Your Ref: OWPC18851
Our Ref: AW/129/18/HH
Please ask for:
Mr R Castro-Parker

14th June 2018

Loft conversion & single storey side extension.
20 Aldwick Gardens Aldwick

Item#	Quantity	Title/Name, designation, material, dimension etc	Article No./Reference
Designed by	Checked by	Approved by - date	Filename
16		March 2018	1208 11250
20 Aldwick Gardens			
Proposed Extensions			
03			Edition
			Sheet

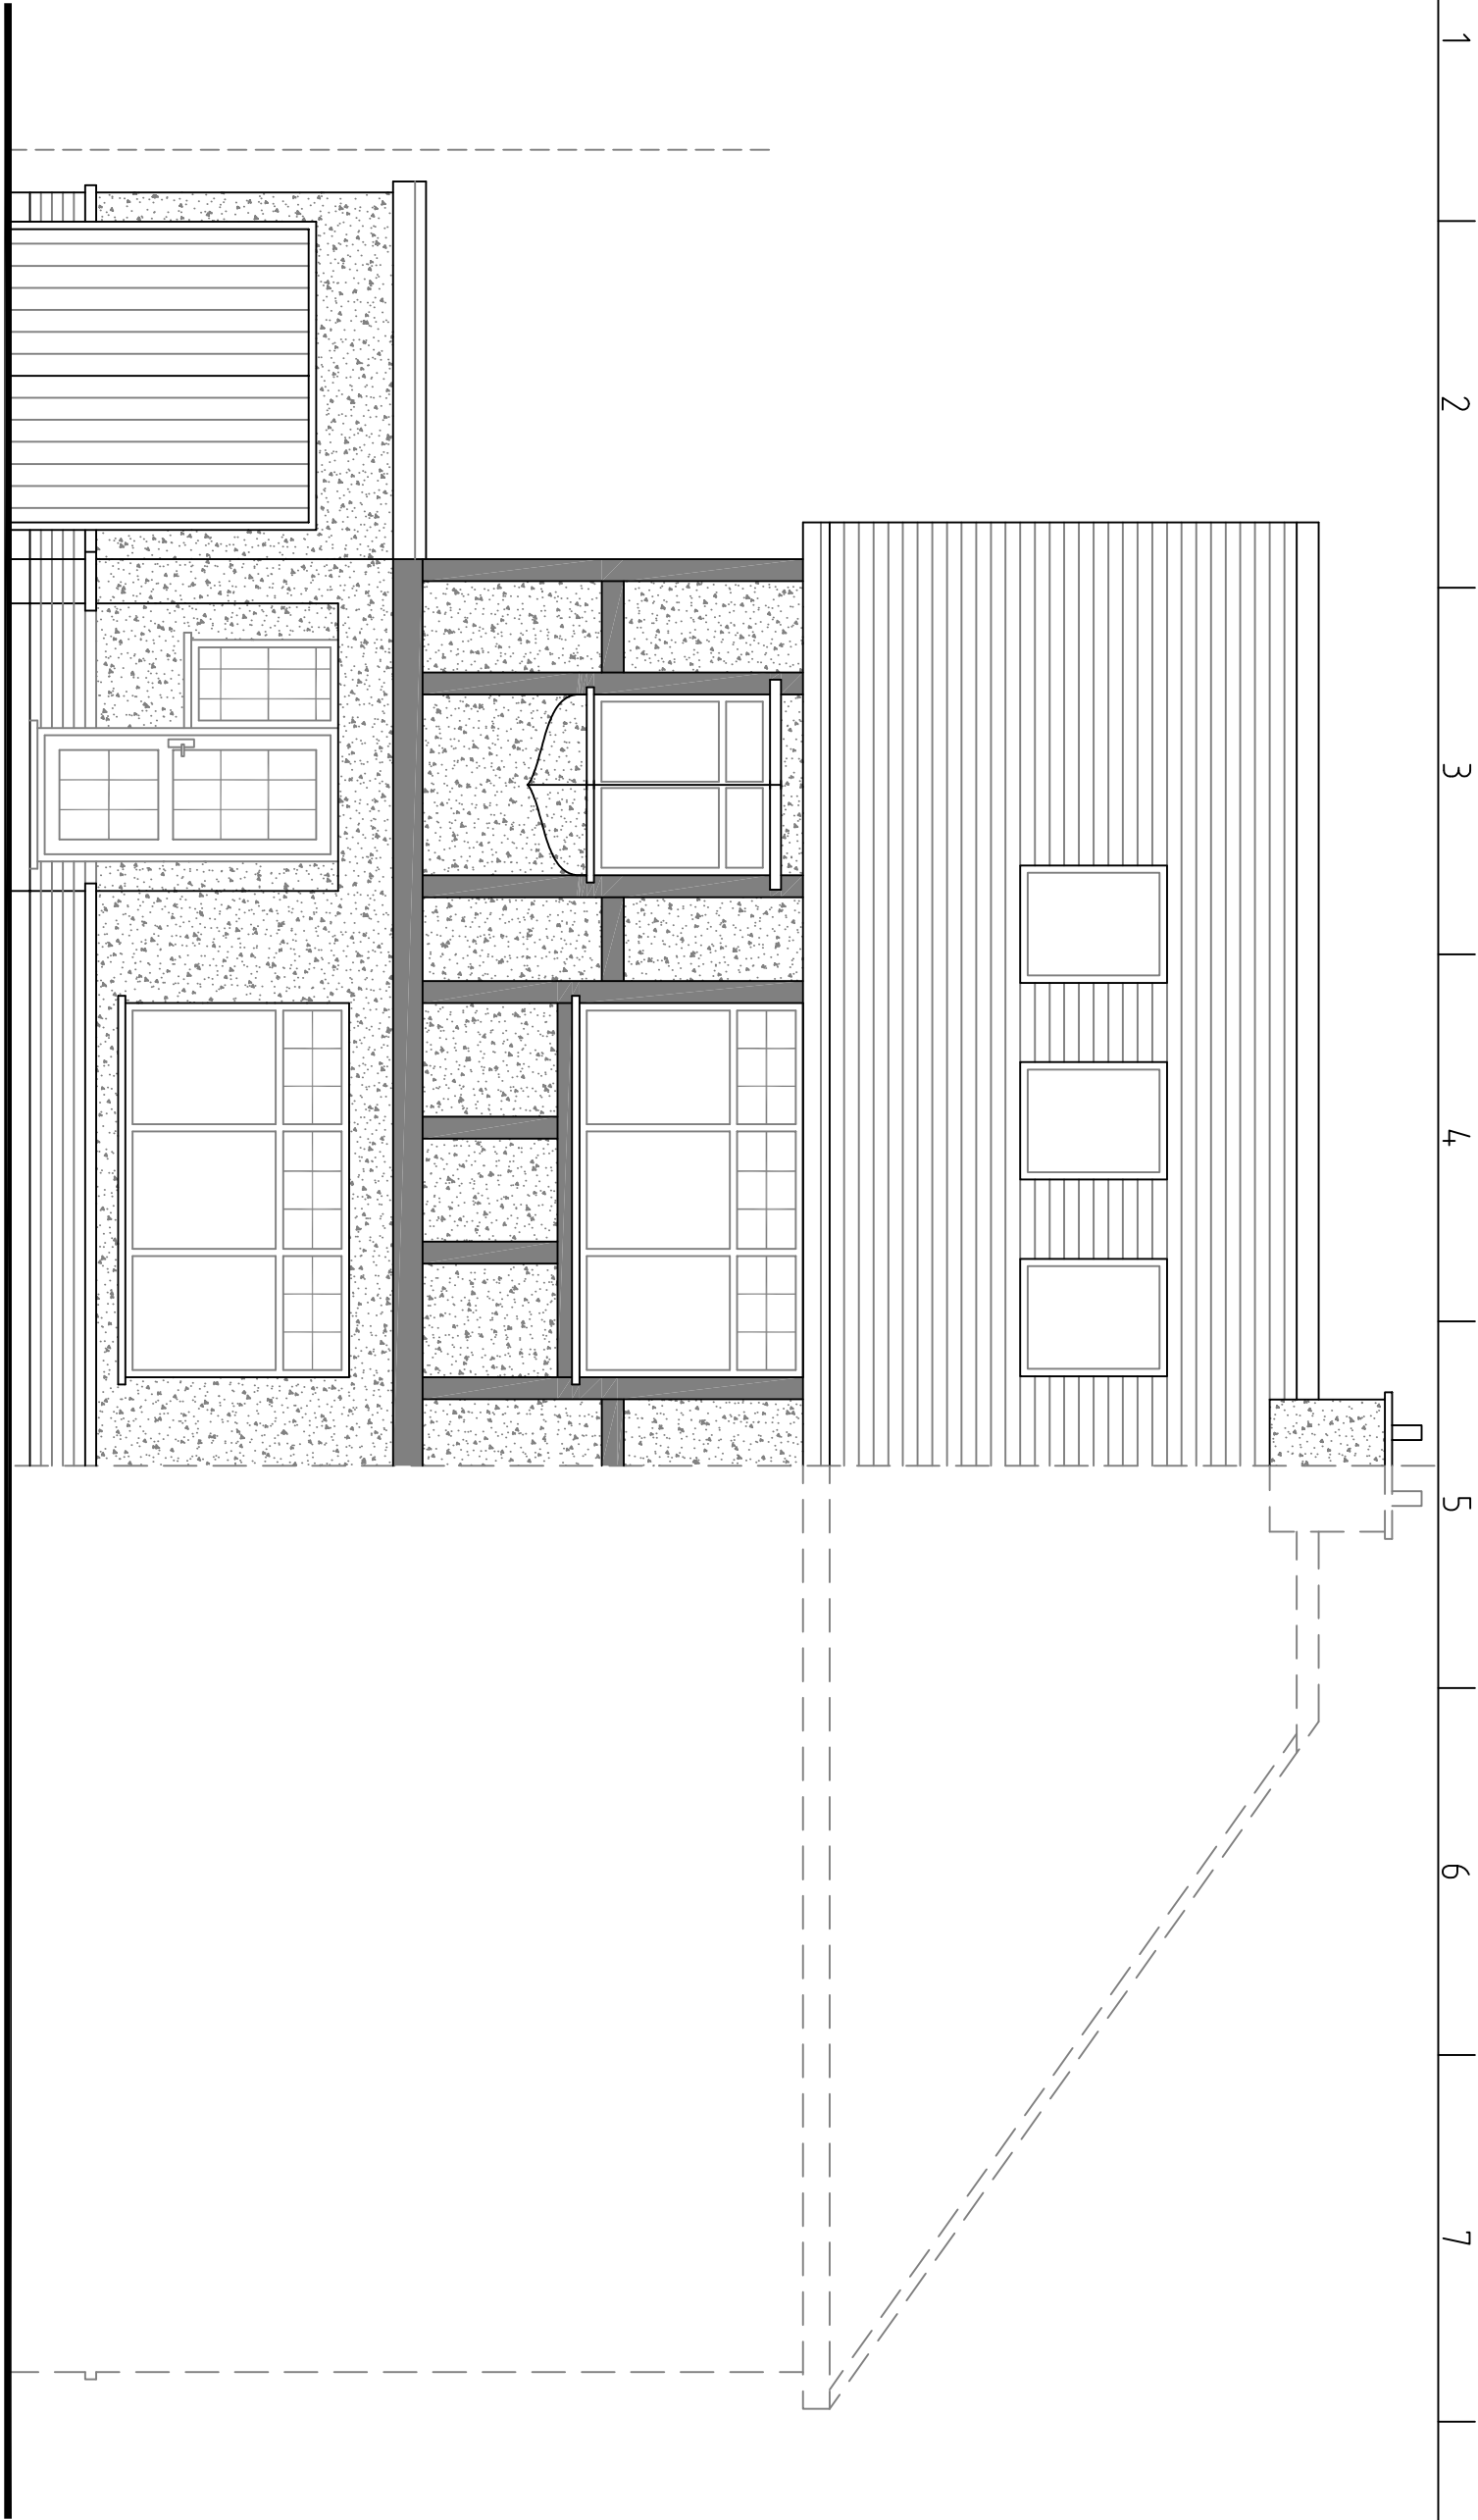
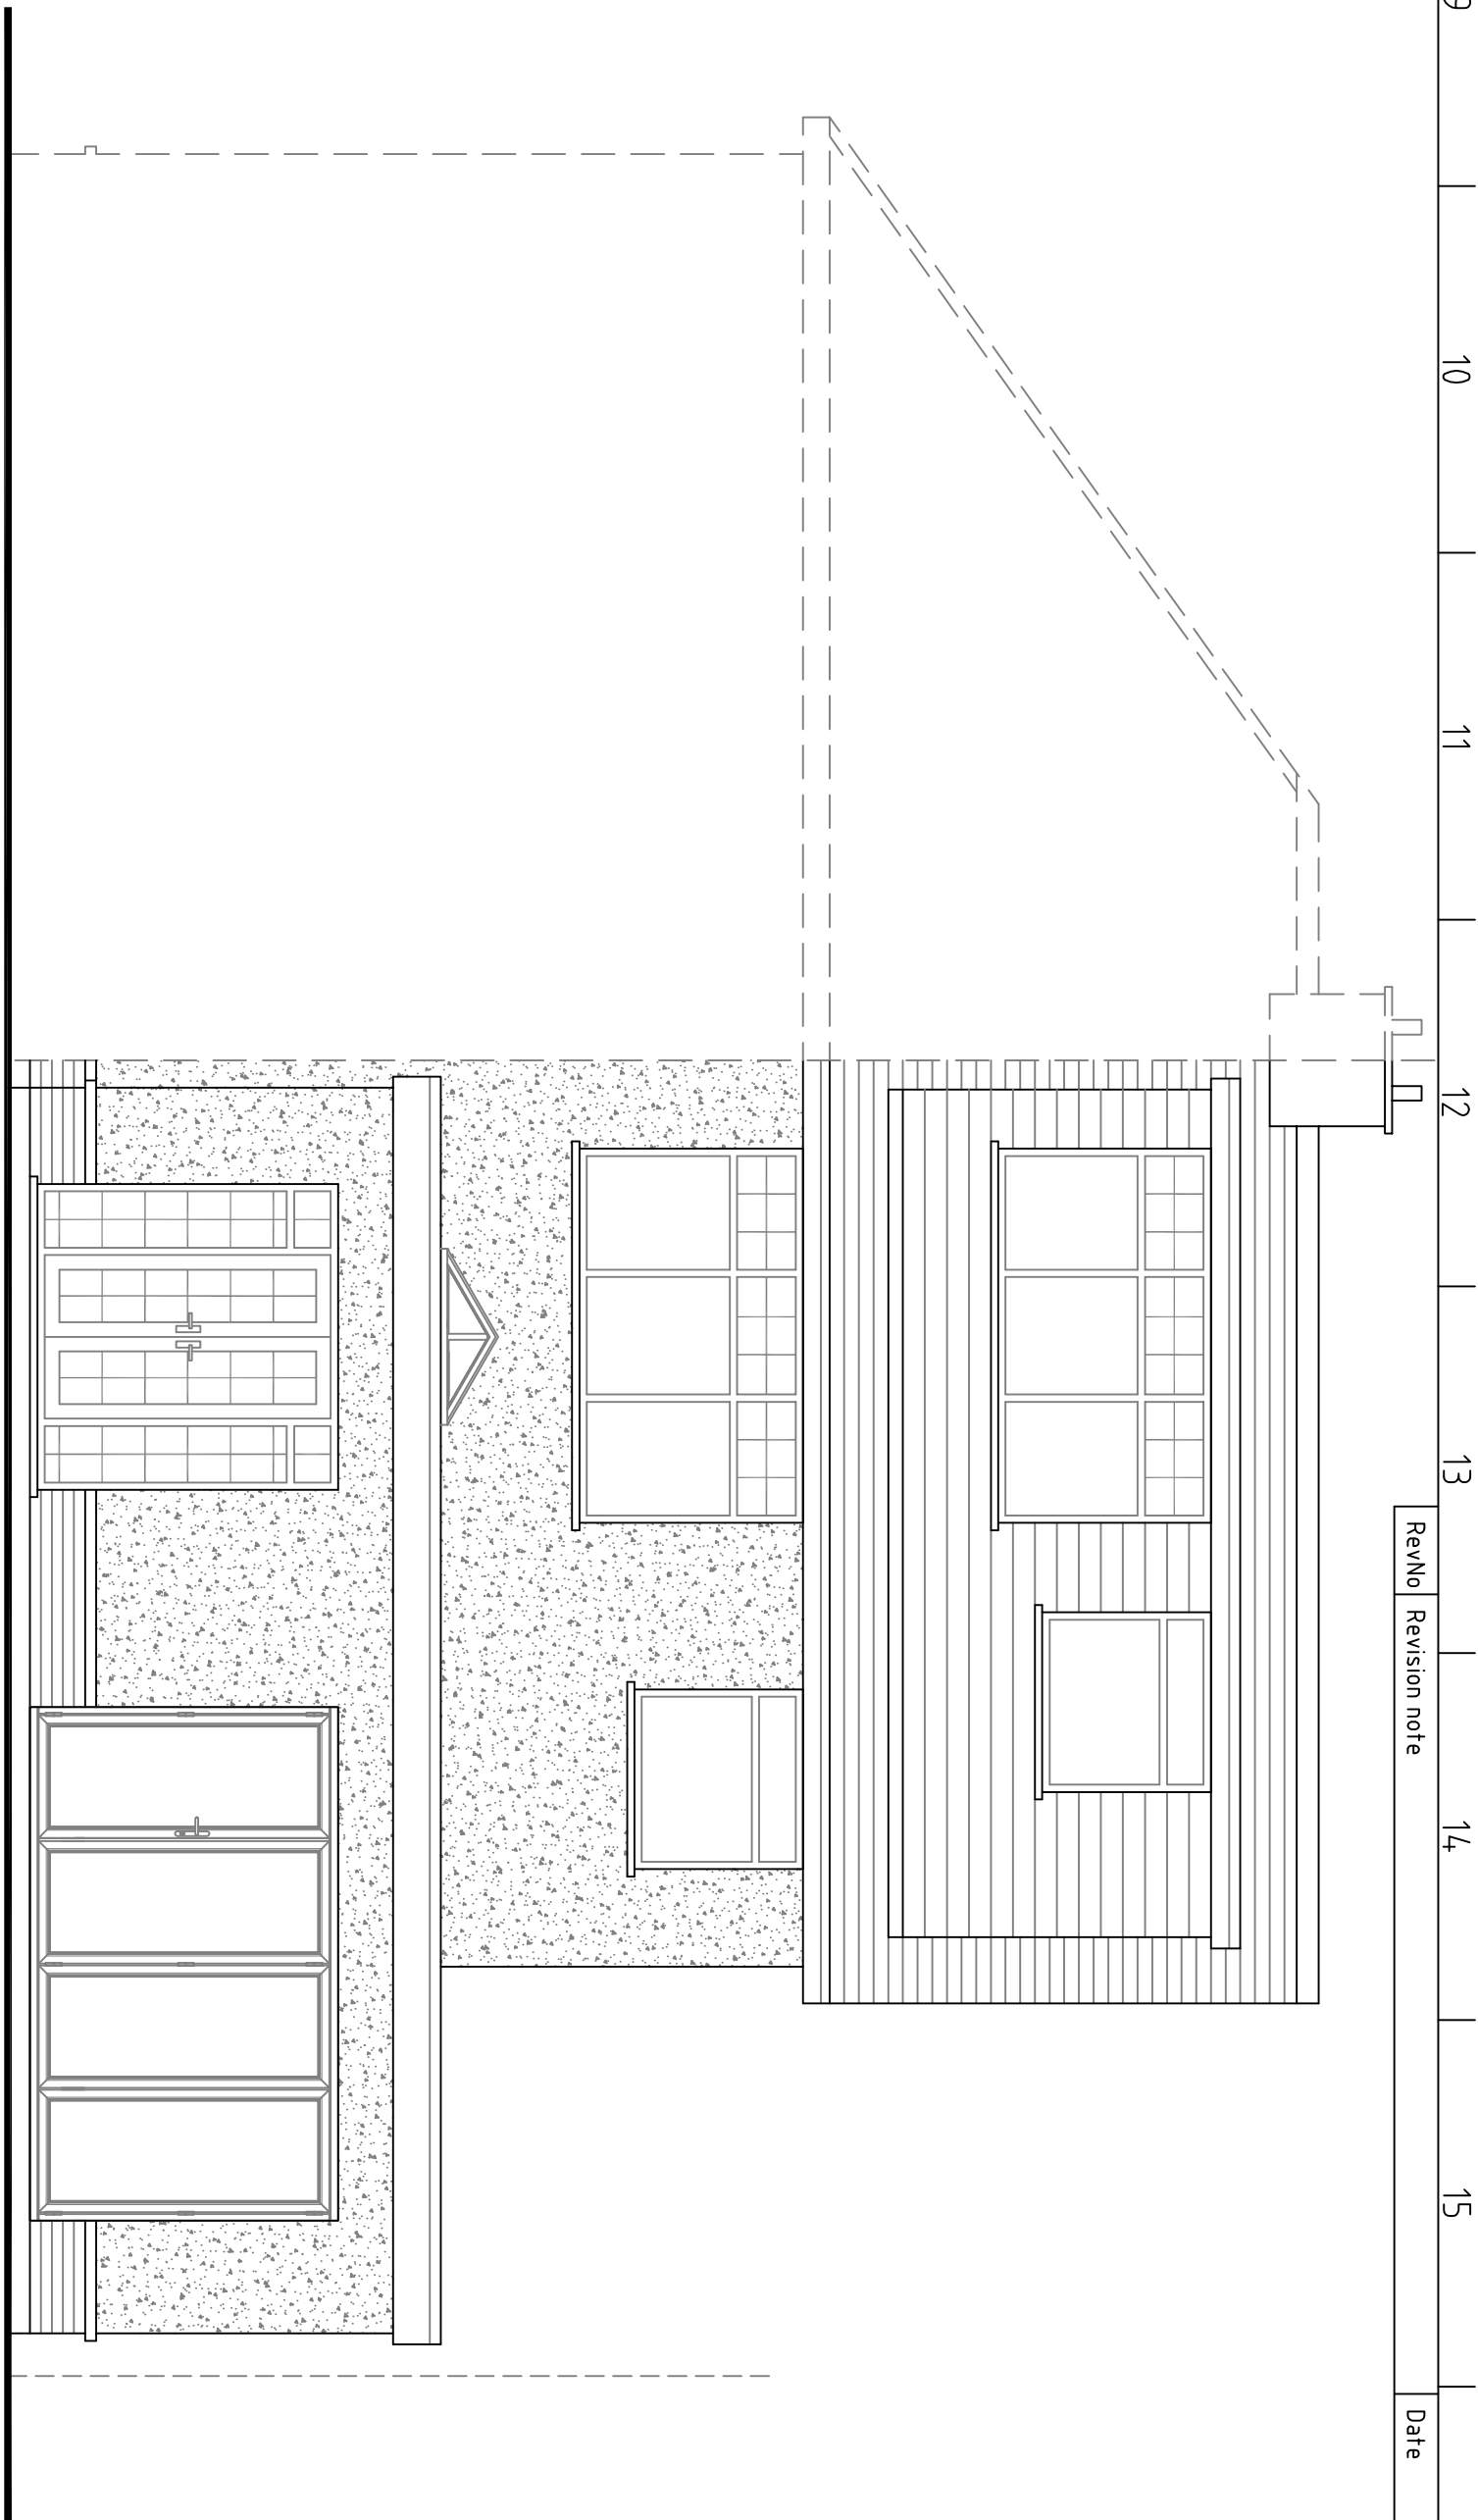
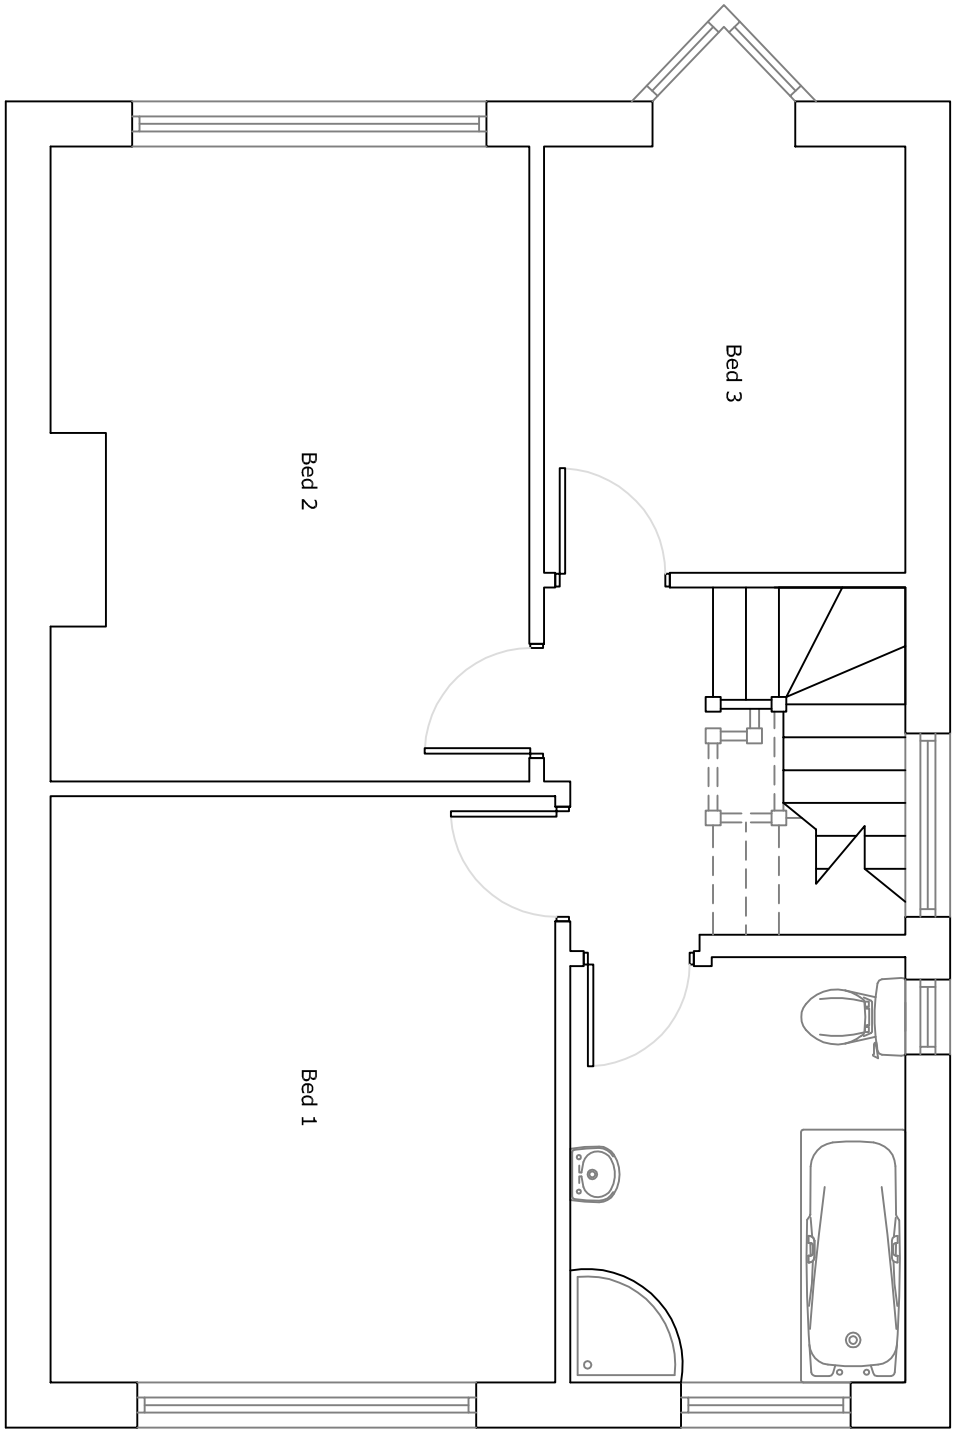
Members strongly opposed the application on the grounds that the proposed conversion and extension does not sympathetically relate to and is not visually integrated with the existing building in siting, design, form, scale and materials. Therefore Members agreed that the application is in direct conflict with Policy Dev 19 (i) of the Arun District Local Plan 2003
